**WEST SUSSEX COUNTY COUNCIL
STRATEGIC PLANNING CONSULTATION**

DATE: 7 May 2015

SUBJECT: FP/55/15/PL - Erection of 38 No. residential dwellings with associated access, parking, landscaping & works (amended proposals for site already approved for residential development).

Site 6 Phases 4 & 5 Land North of Felpham, Felpham, PO22 8FX

Diagram. 7. Proposed Phase 5A Site Layout.

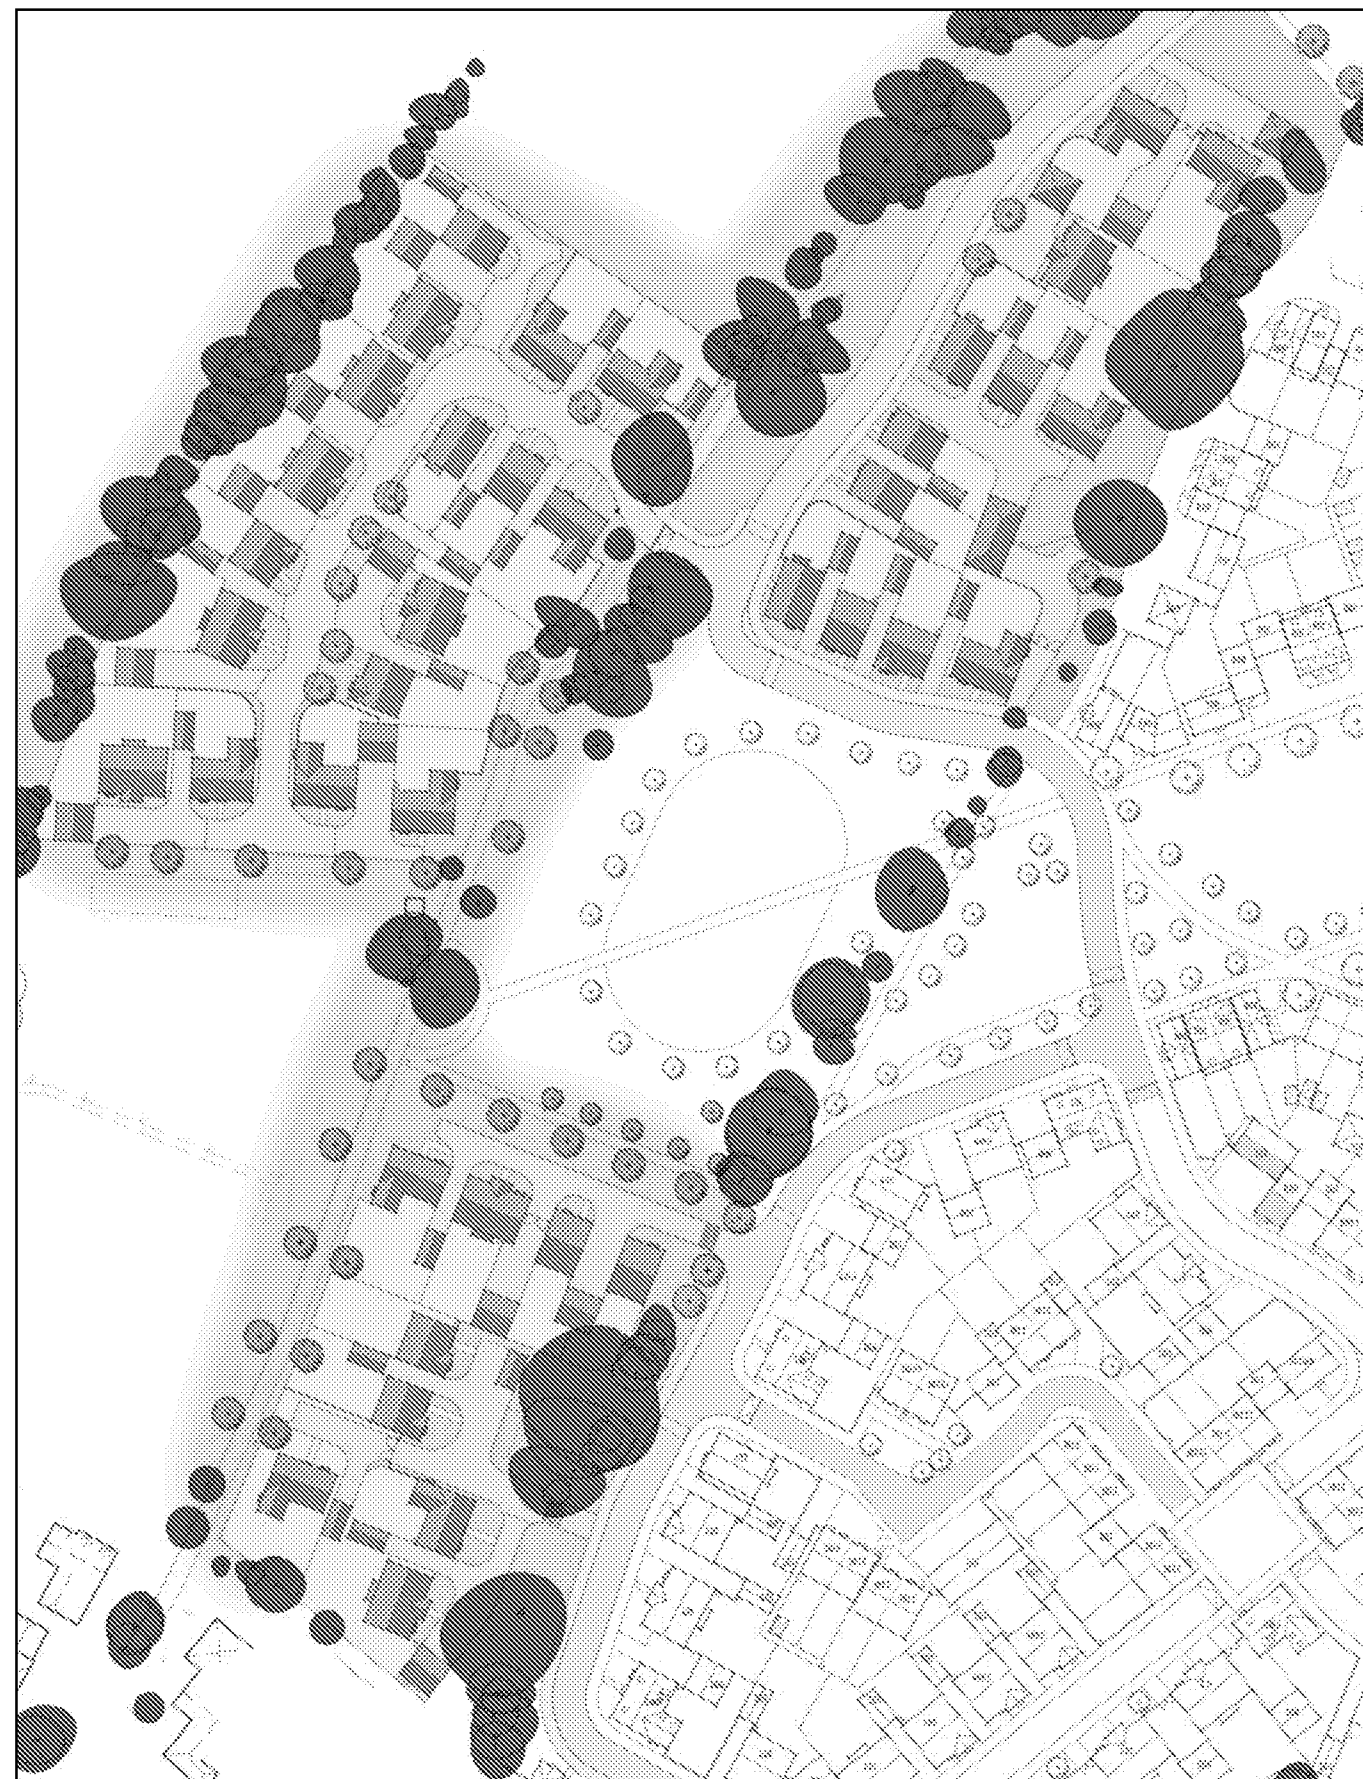
The submitted plans show the public highway within the red line, however there does not appear to be any changes to the approved road layout. Can the applicant please confirm there are no changes proposed to the design and construction of the road and footway layouts.

The application form states there are to be 114 parking spaces, however the Design and Access statement suggests there will be 88 (a decrease from the approved 91). Can the applicant please confirm the parking provision, on a plan to establish the level of parking overall and the provision proposed for each dwelling.

The Bognor – Barnham cycle route (secured through the outline consent) runs through the development (south/north), however this does not appear to be shown on the mapping provided, can the applicant ensure it is included, and labelled, on the planning drawing.
